KIRKLEES METROPOLITAN COUNCIL DEVELOPMENT & MASTER PLANNING SERVICE

DELEGATED DECISION FOR PRIOR APPROVAL FOR CHANGE OF USE FROM COMMERCIAL, BUSINESS AND SERVICE USES TO DWELLINGHOUSES

Reference no. 2024/CL/90501/W

Site Address	Clifton House Surgery, 1, Church Street, Golcar, Huddersfield, HD7 4AQ
---------------------	---

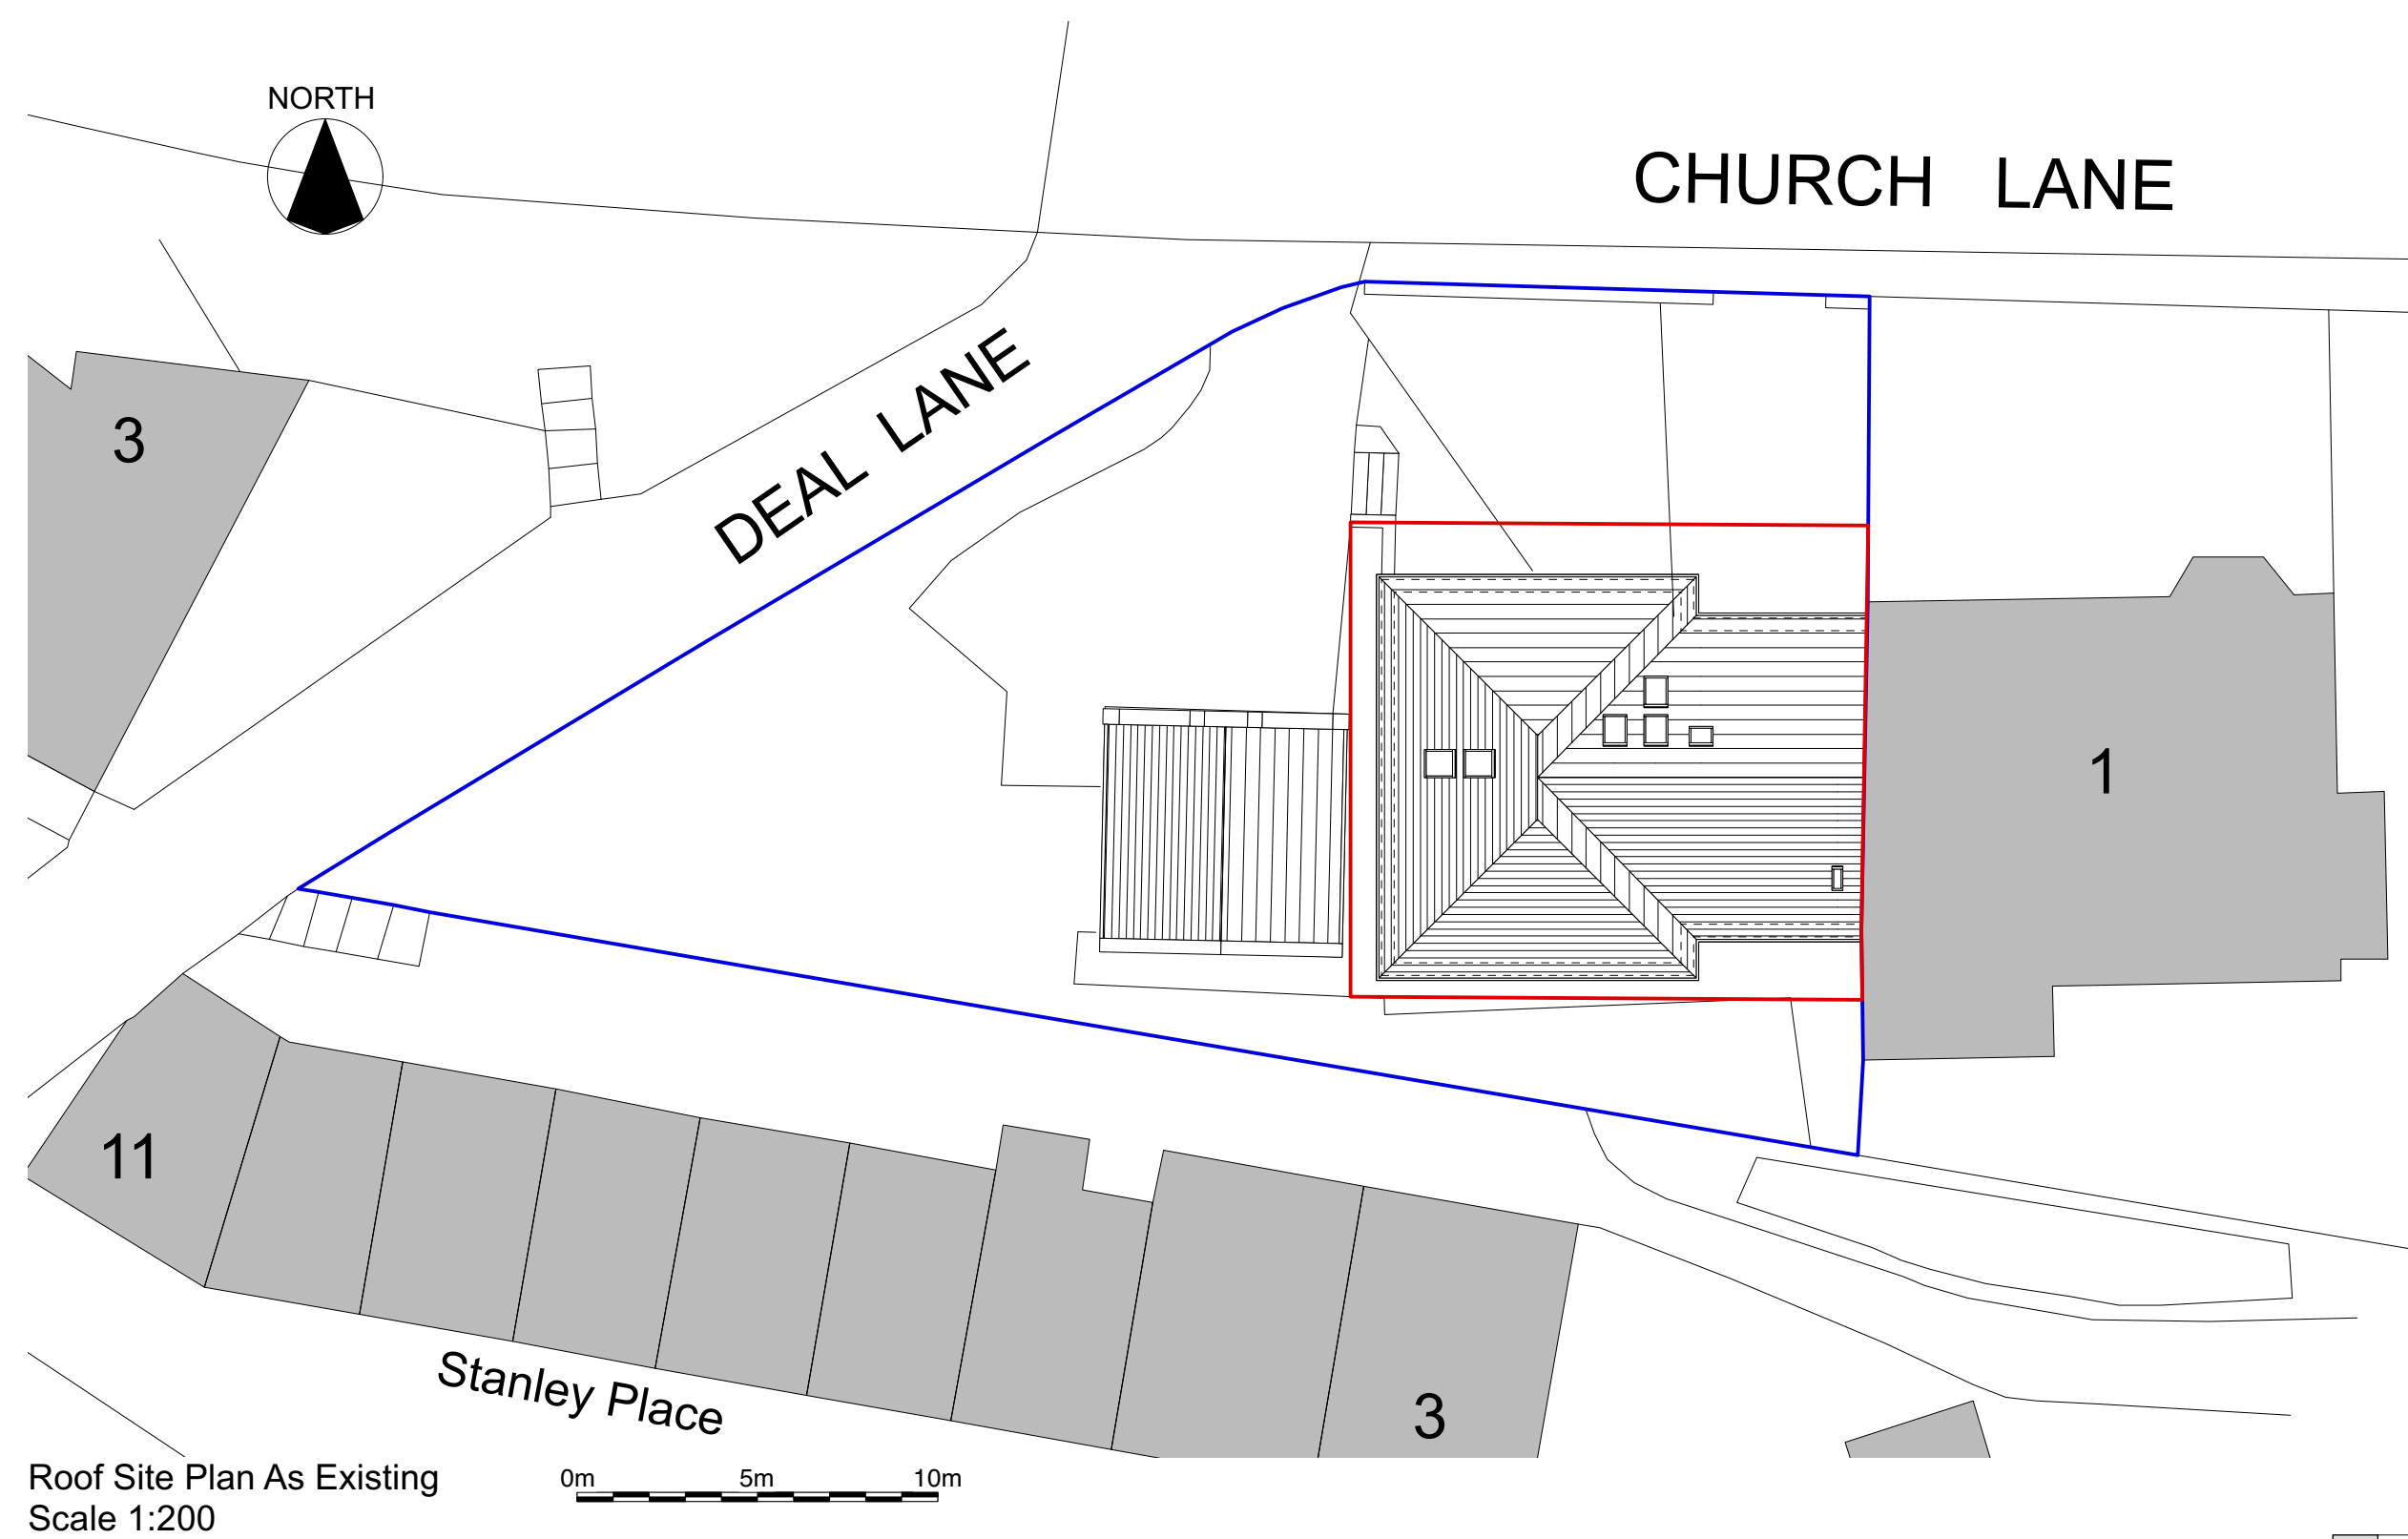
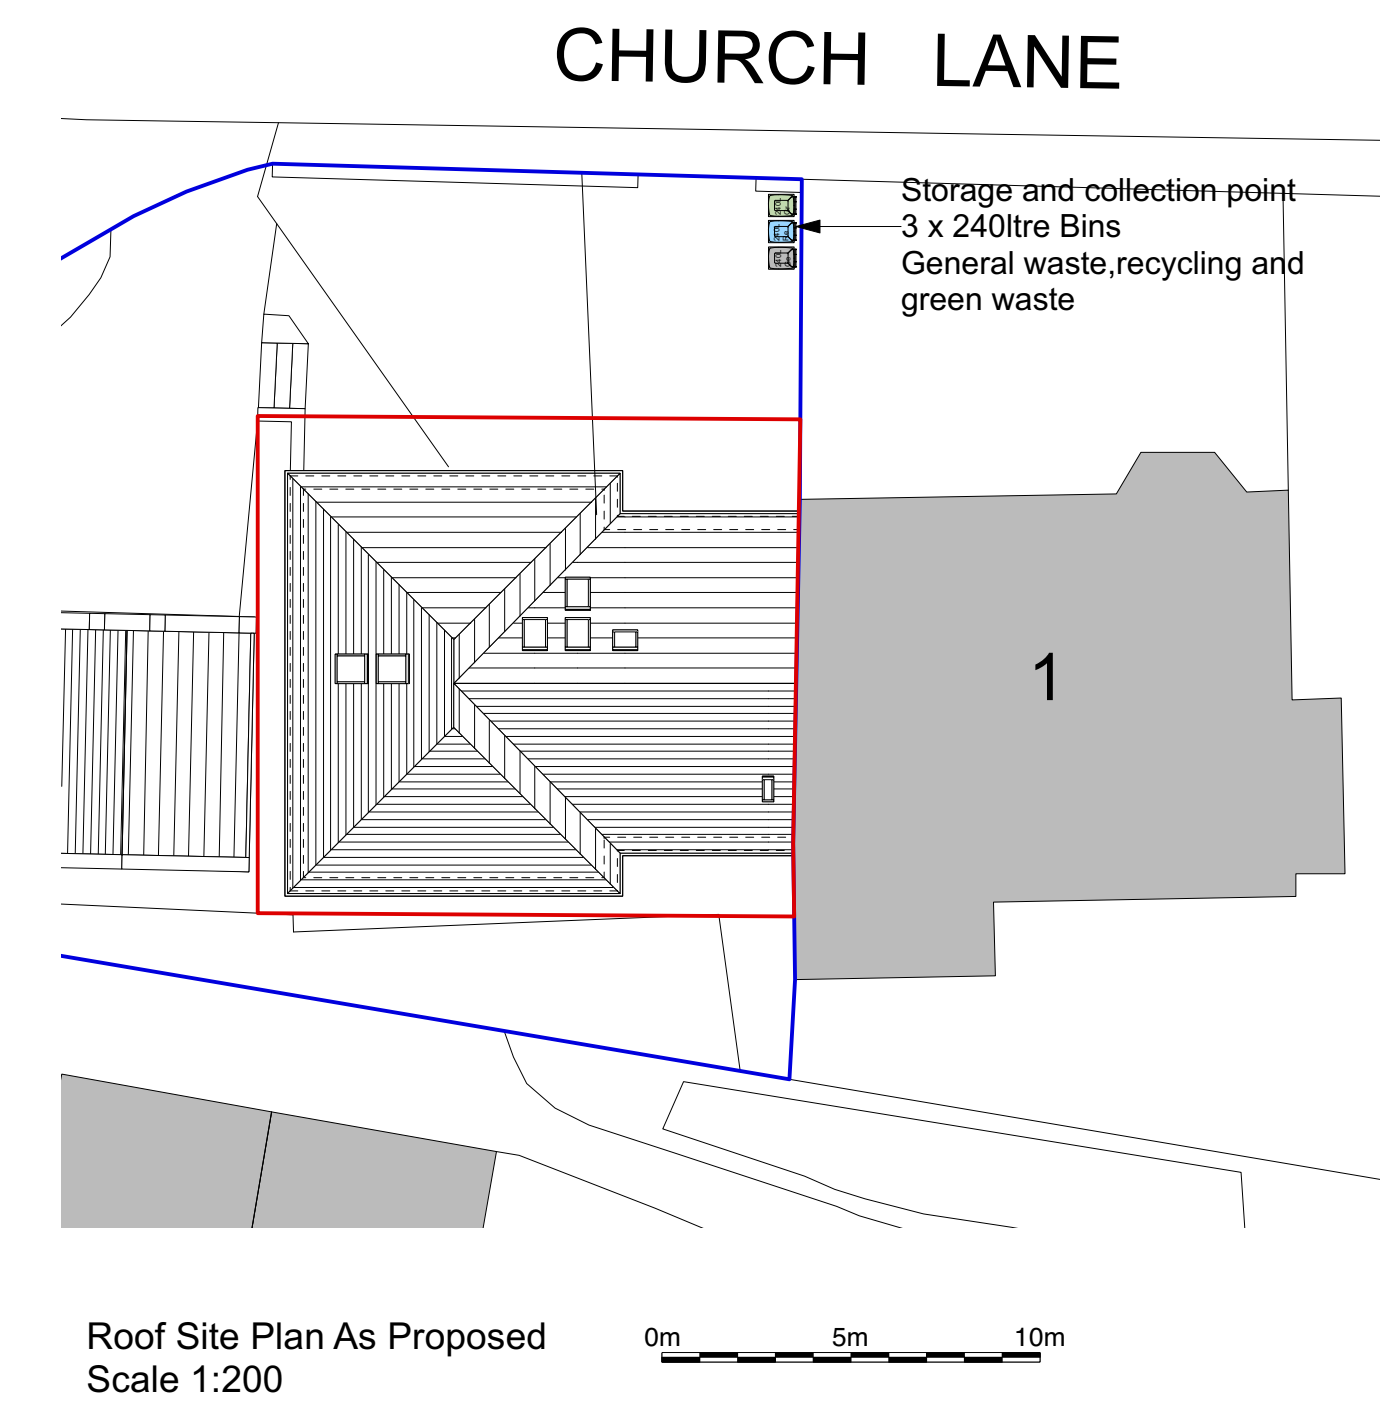
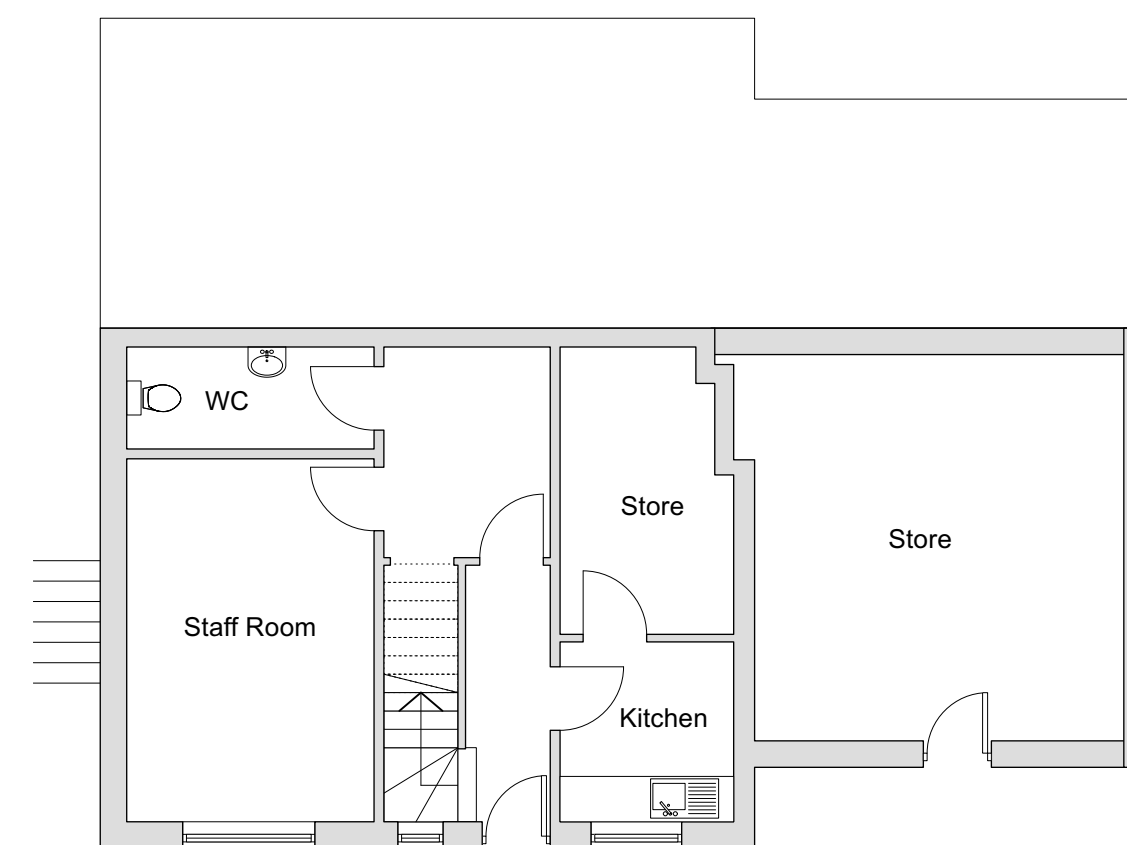
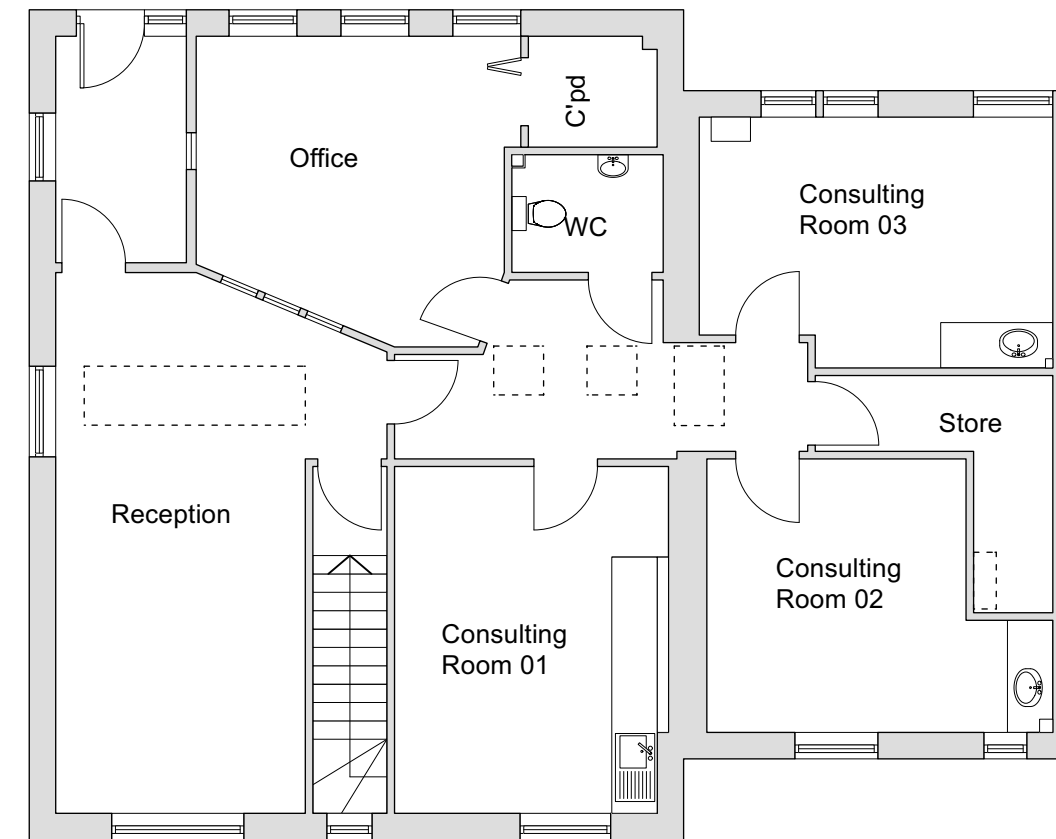
In terms of waste management, Officers have provided comments which cite that 3 no. 240ltr bins would be required for the property to provide residual and recycling provision with adequate space for a third bin for garden waste. It is noted that due to the split level of the property the bin storage would need to be to the front of the property.

The comments were sent to the Agent for the application and an updated plan was submitted and received on 3rd April 2024 which indicated the provision of 3 no. bins which would be located adjacent to the entrance of the site.
